Your Reference: MP10\_0057 MOD 3  
Our Reference: I0M684 vol3 – SYD11/00690  
Contact: Hans Pilly Mootanah  
Telephone: 8849 2076

**MODIFICATION TO AMEND CONDITION B1A(F) AND B12(A)  
AT 132-138 KILLEATON STREET, ST IVES**

Reference is made to your letter dated 15 September 2011 concerning the abovementioned Major Project Application which was referred to the Roads and Traffic Authority (RTA) for comment.

CARPARK LEVEL 2 STAGE-2
SCALE 1:200

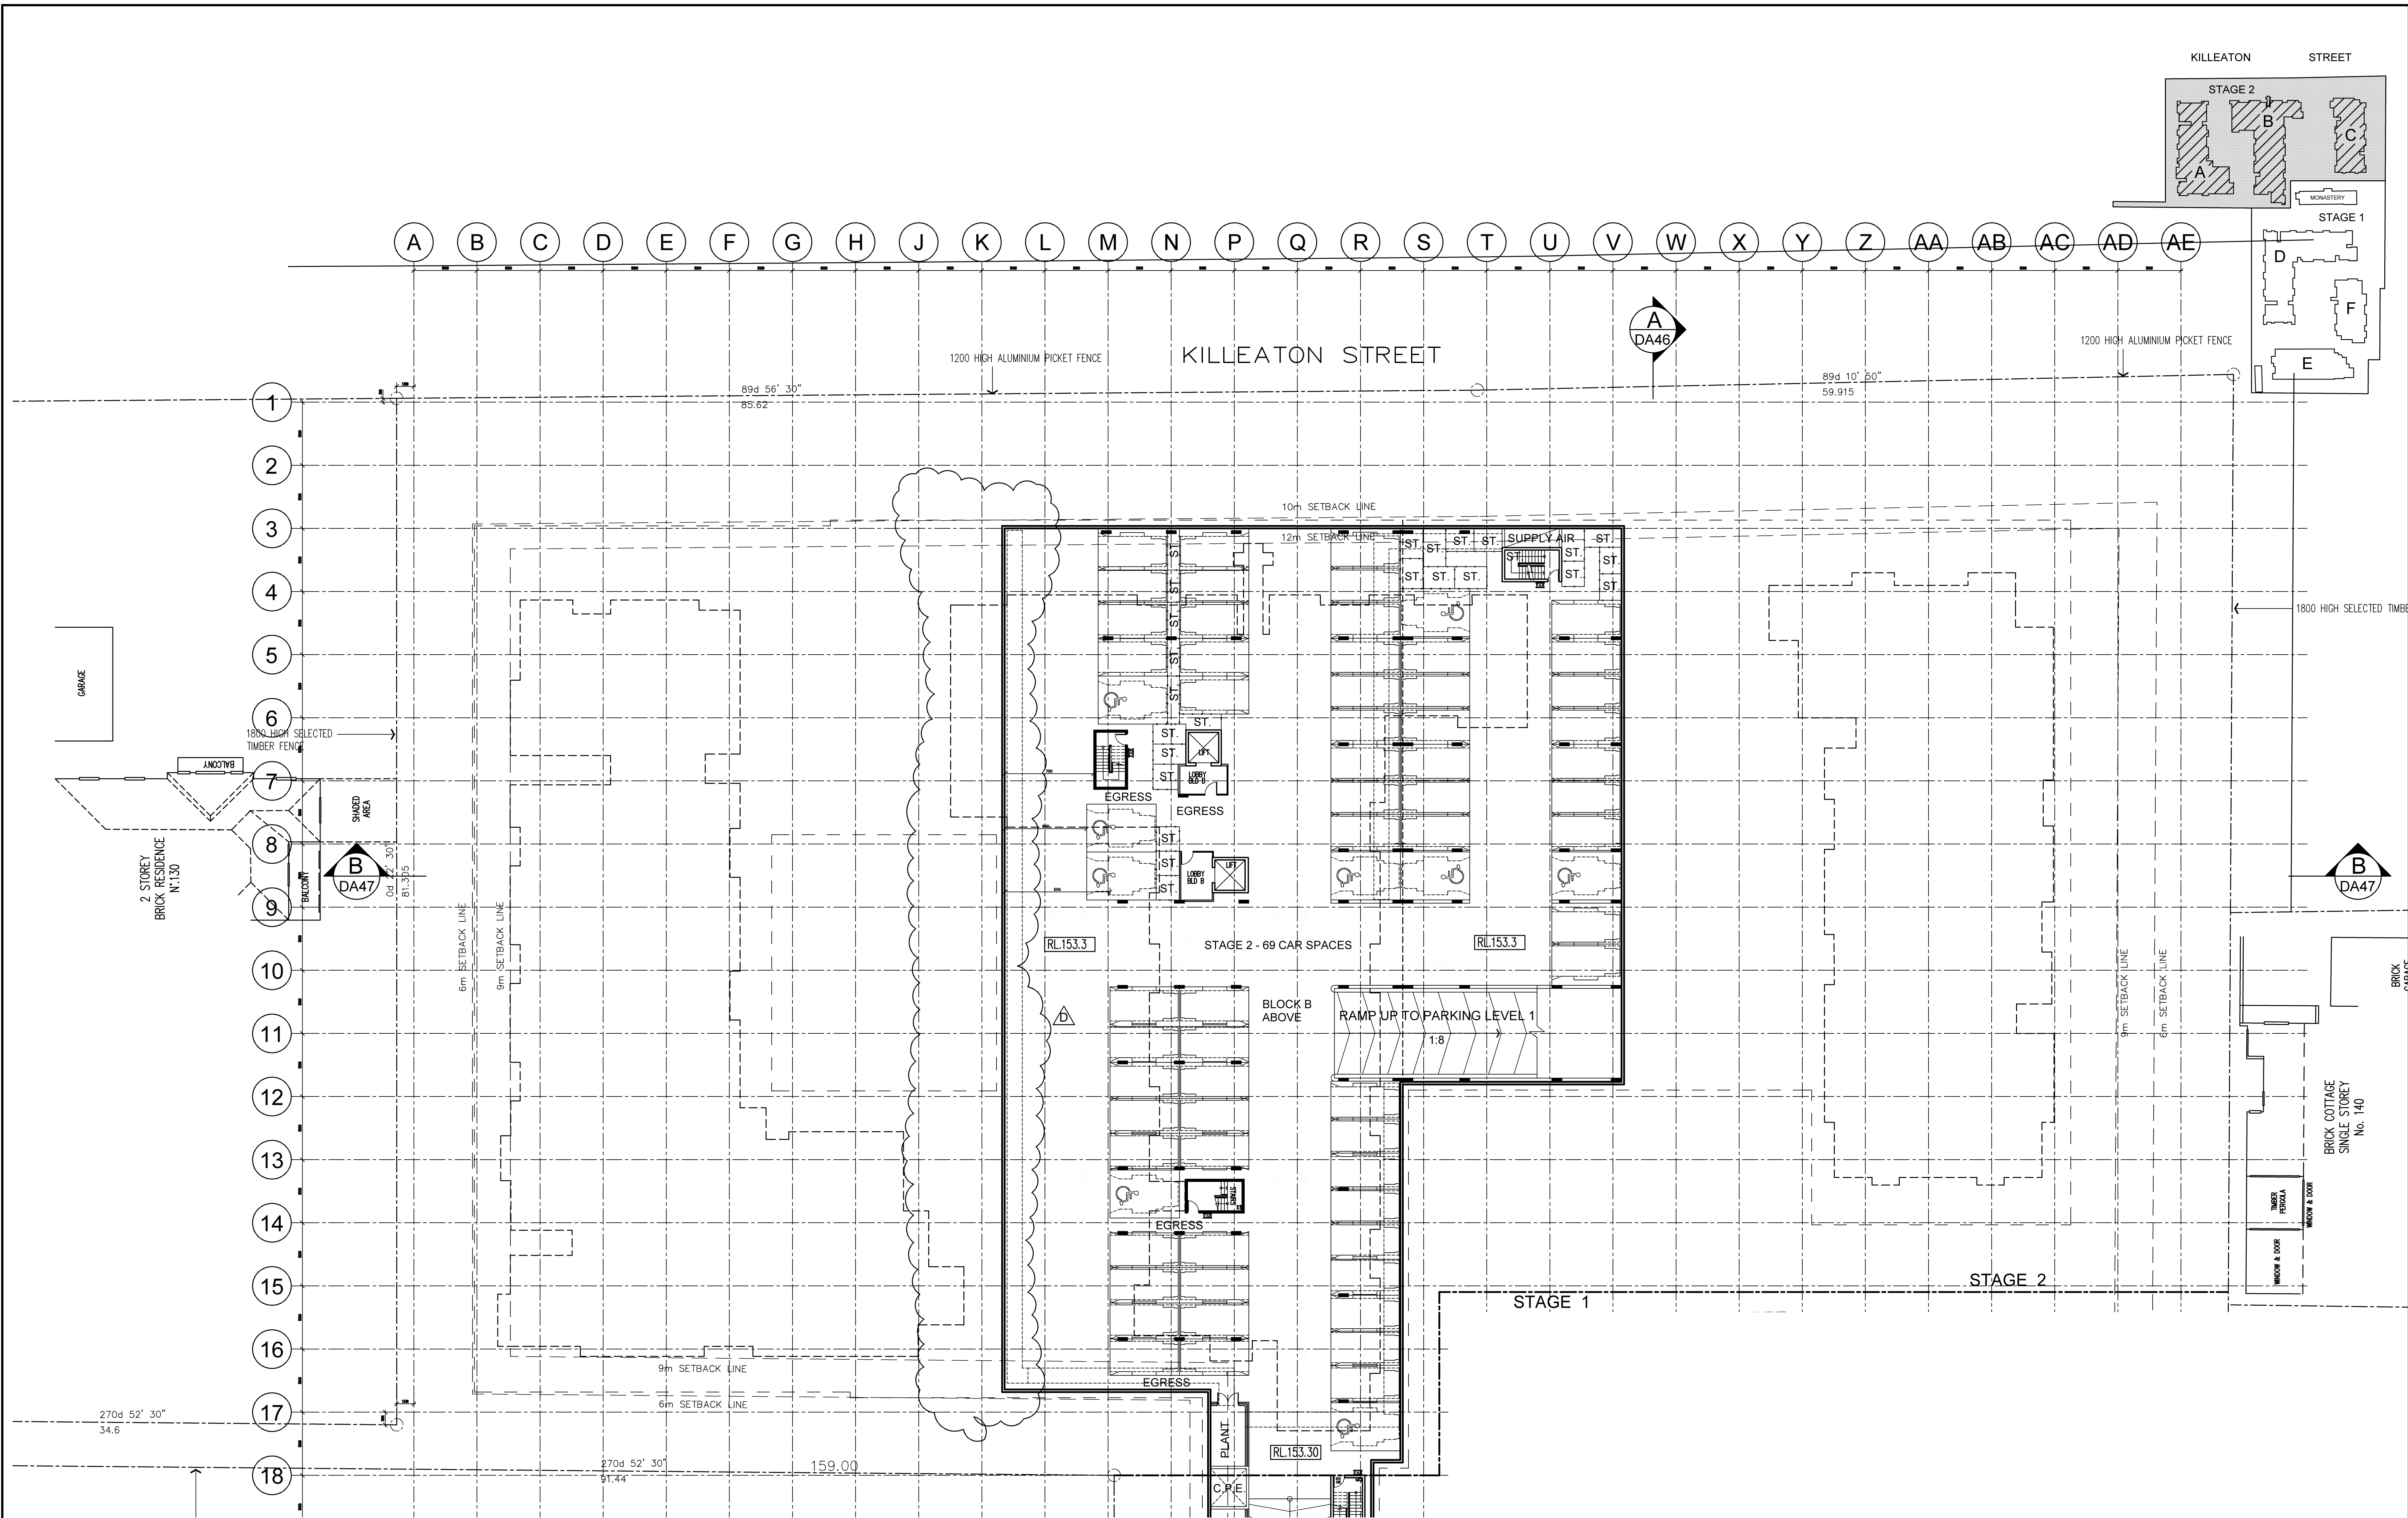
- i. The RTA does not support the proposed reduction in visitor parking from 75 spaces to 48 spaces. This development is in an area of St Ives which has access to very limited public transport service during off peak and week ends. The majority of visitors would be using a private vehicle.
2. However, the RTA would not object if the applicant were to reduce the residential car parking spaces and to provide residential parking spaces in accordance with Ku-ring-gai Council requirements.
